**KIRKLEES METROPOLITAN COUNCIL  
INVESTMENT & REGENERATION SERVICE**

Reference No:	<b>2023/44/91210/W</b>
Site Address:	Thornton And Ross Ltd, Manchester Road, Linthwaite, Huddersfield, HD7 5QH
Description:	Discharge condition 6 (noise barriers), 7 (finishes colour of plant and dimensions of pump and chiller ) on previous permission 2021/92779 for erection of plant deck consisting of new heating, ventilation and air conditioning system (HVAC) with associated works
Recommending Officer:	Teresa Harlow

**DECISION – DISCHARGE OF CONDITION SPLIT DECISION**

## Officer Report

Document Number
AAA5581-RPS-XX-XX-DR-A-0010

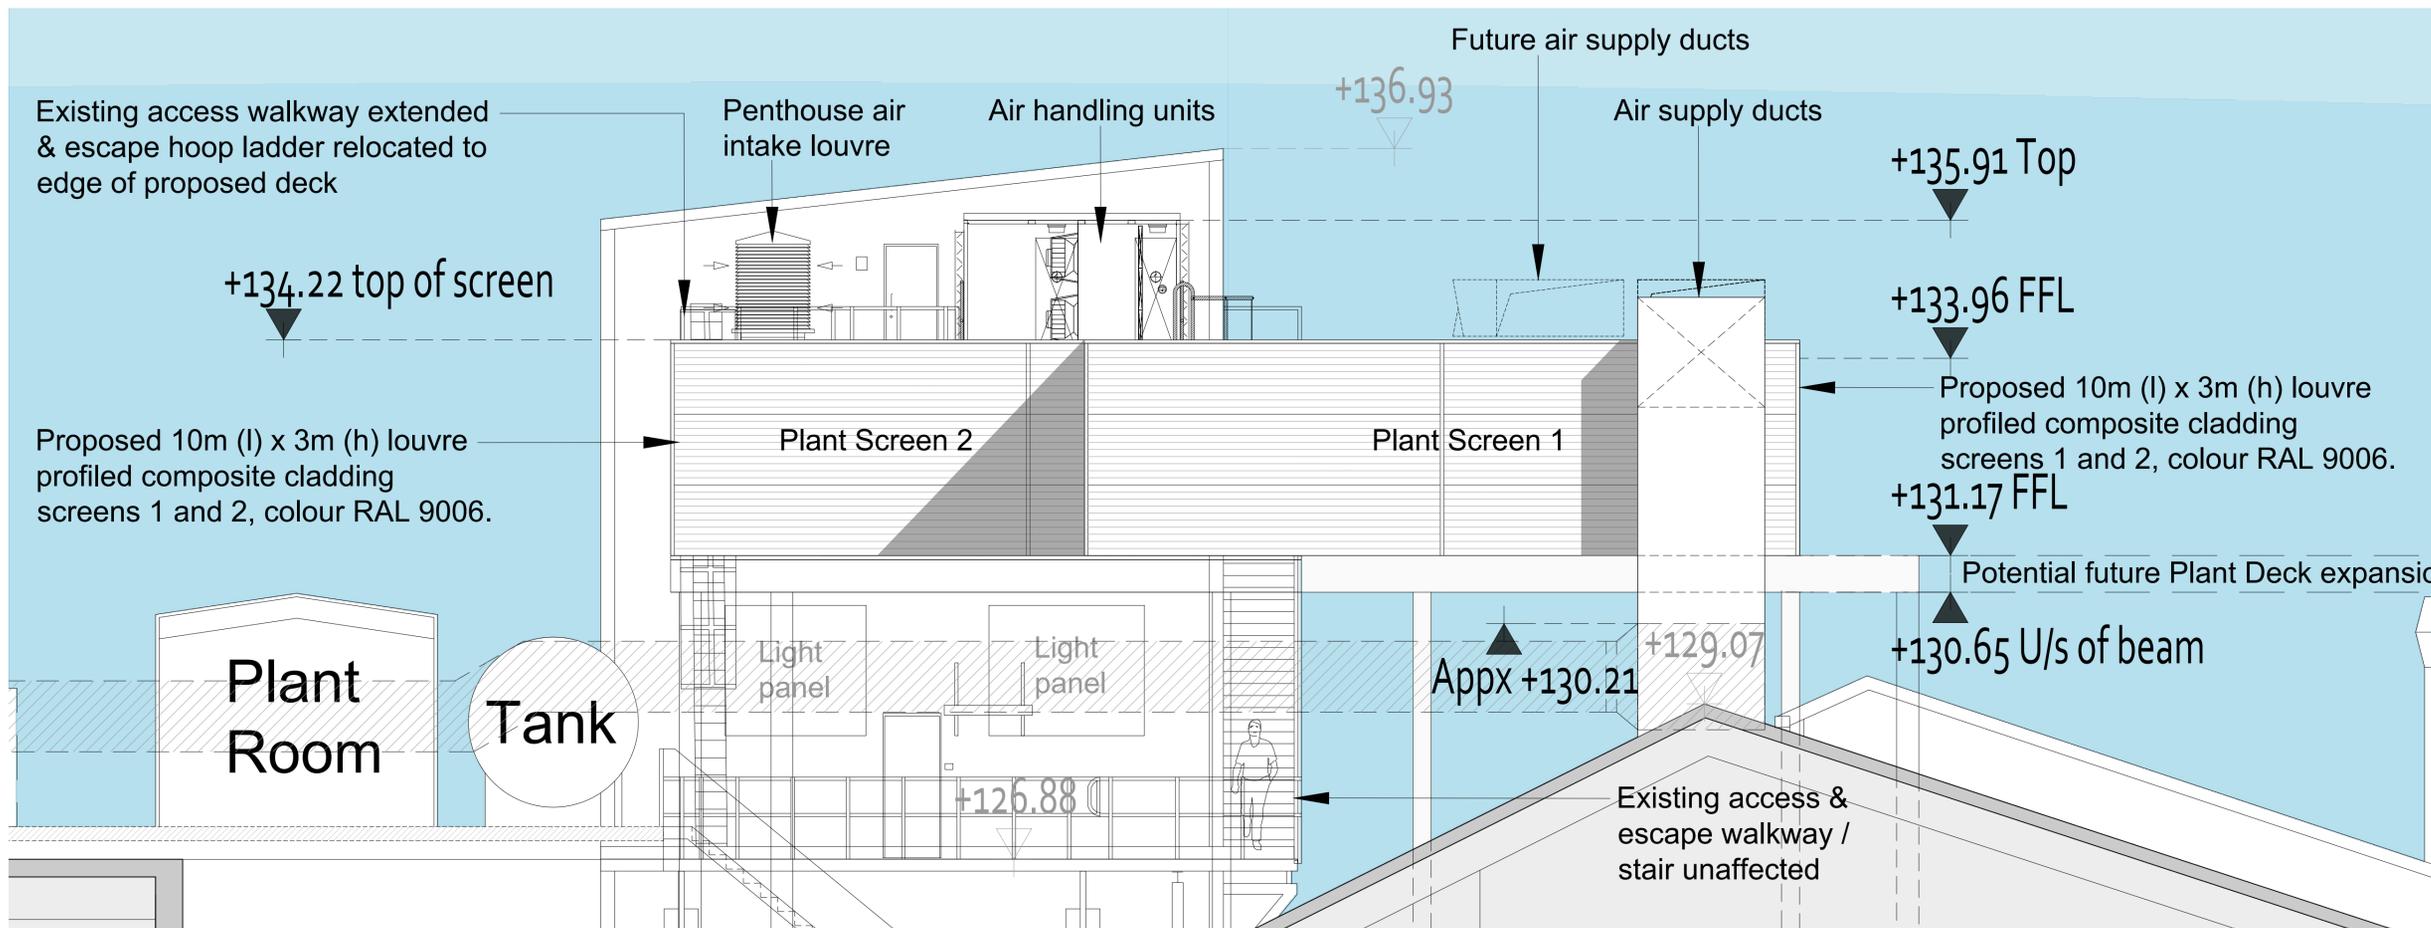
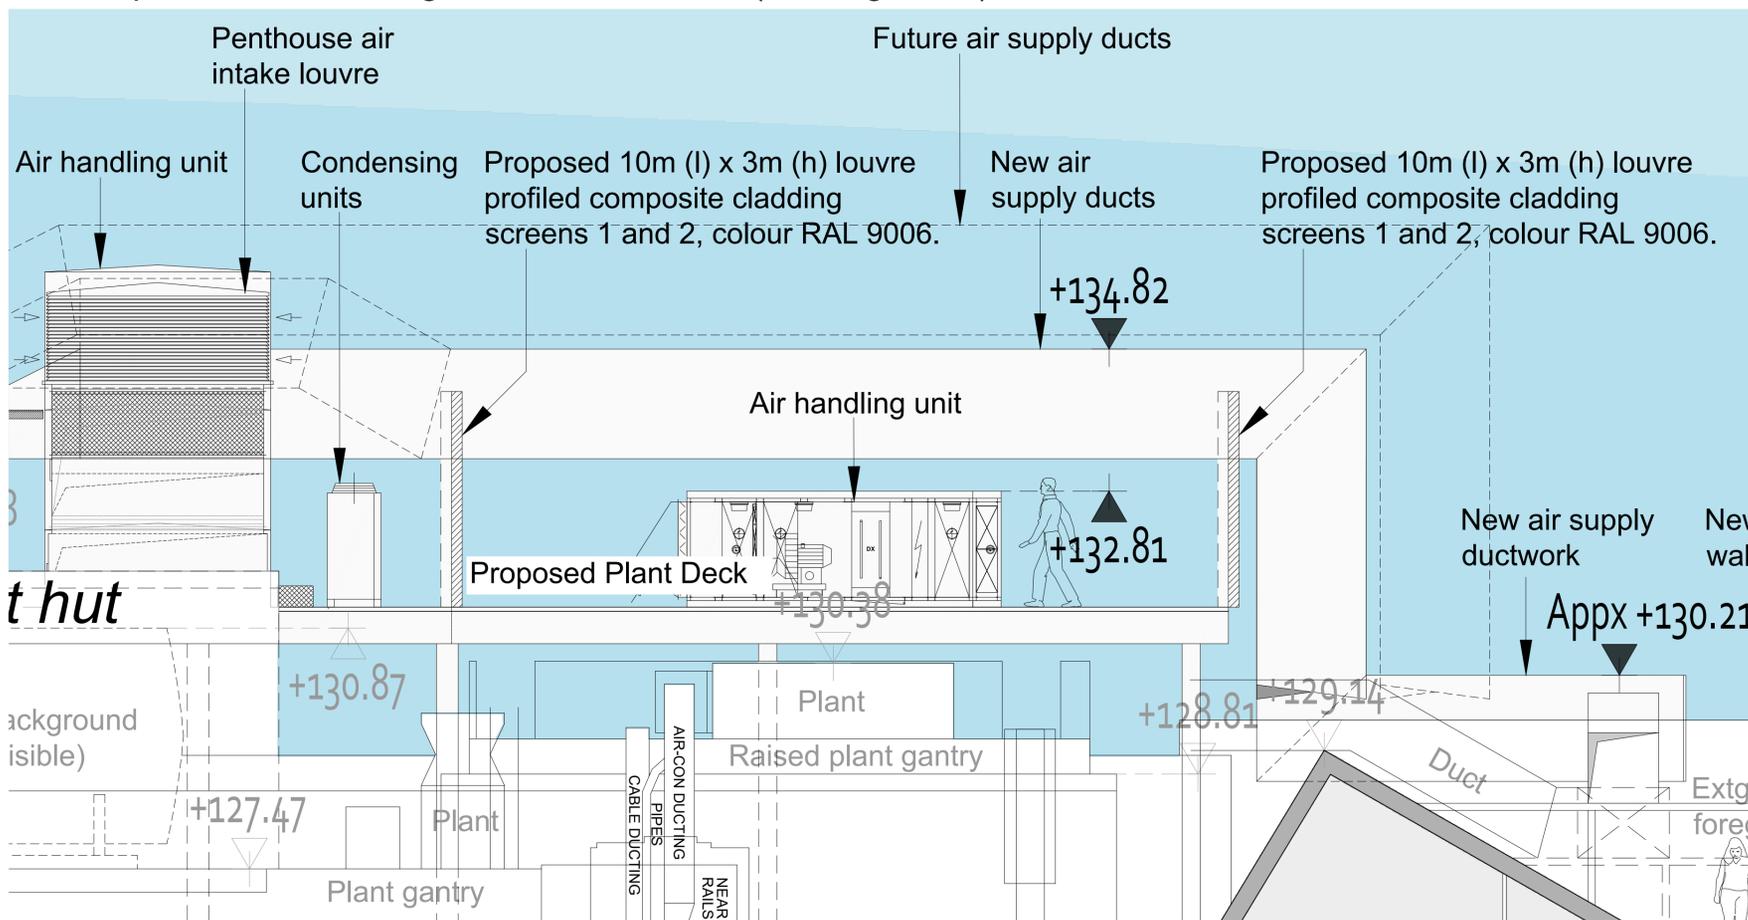
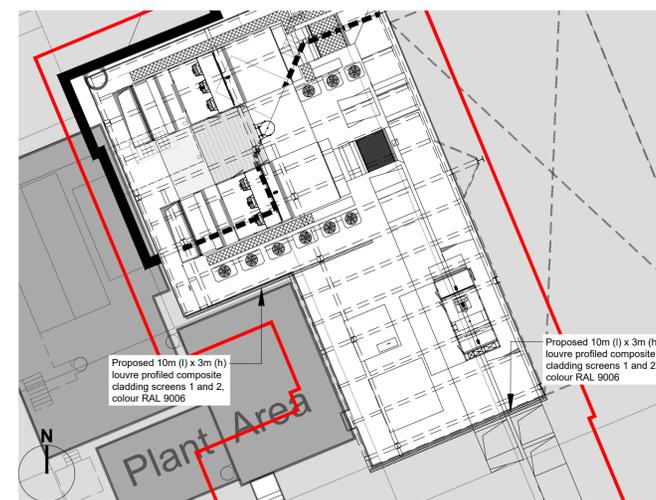
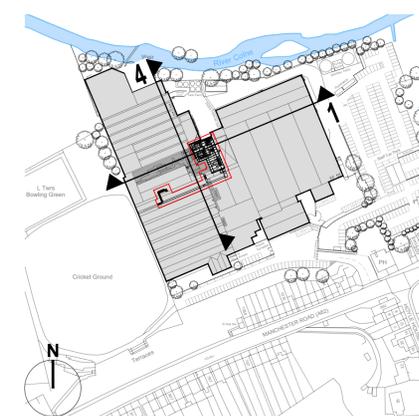
The information submitted in support of condition 6 includes, in part, the original Noise Impact Assessment. In the original planning application assessment, it was concluded, following consultation with Environmental Health, that whilst the findings of the NIA were accepted, there was uncertainty regarding the final installation of mechanical plant and its respective attenuation. As such the requirements of condition 6, in part, require details of the acoustic specification to be submitted in an addendum report. This is not included in this discharge of condition submission. At this time, it is not possible to discharge condition 6 as the acoustic specification of the noise barriers is not known. The other elements submitted (design details of the noise barriers, including location, elevations, colour, materials) will not be assessed until final details of the acoustic specification are submitted.

An up to date NIA (addendum) to address the uncertainty in the original and submitted NIA is required. If this results in amendments to the submitted Proposed elevations and sectional elevation drawing, these should form part of the amended submission.

You are invited to submit an up-to-date NIA (addendum) to address the uncertainty in the original and submitted NIA under this application (ref 2023/91210). If this results in amendments to the submitted proposed elevations and sectional elevation drawing ref AAA5581-RPS-XX-XX-DR-A-0010 , this should form part of the amended submission.

Advanced Engineering AE Mixers.com Middleton Ltd
					Customer - Thornton & Ross Plant - AdPro 2
0	First Issue	AB	AB	12.8.21	Description - Chiller & Buffer Skid
Rev	Description	By	Ckd	Date	Drawing No - P-030-103

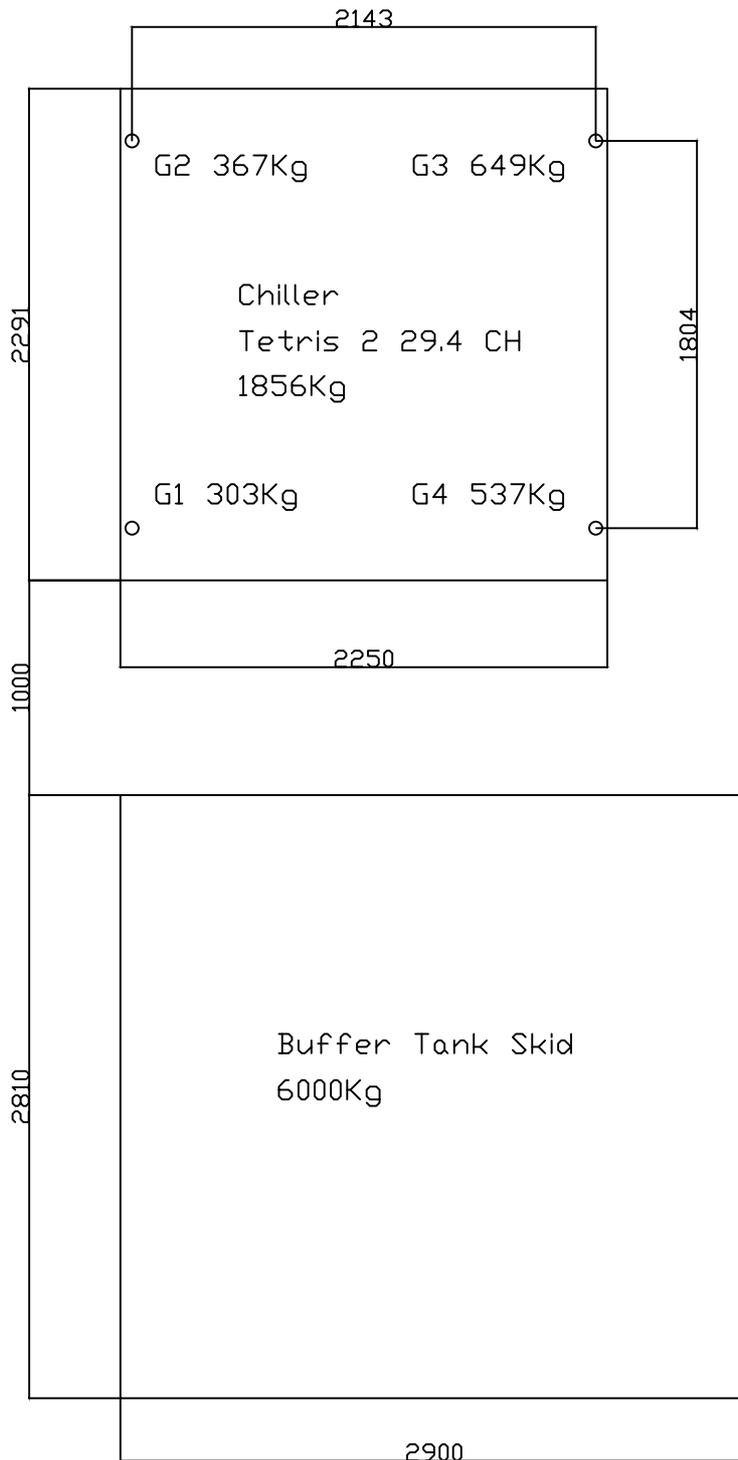
The submitted information provides section and elevation details (which explicitly states that RAL9006 – grey colour would be used for noise barriers alone), and functional detail of the dimensions of the plant. Sufficient information is considered to have been provided to conclude that the dimensions of the 4no. pumps and 1no. chiller would preserve the visual amenities of the area and designated heritage assets. They would be seen against the mass of the sprawling industrial complex and would be located in a central location within the site.

The proposed dimensions and originally stated colour finish are approved. The requirements of condition 7 now require that the plant be installed in accordance with these approved details and retained as such thereafter.
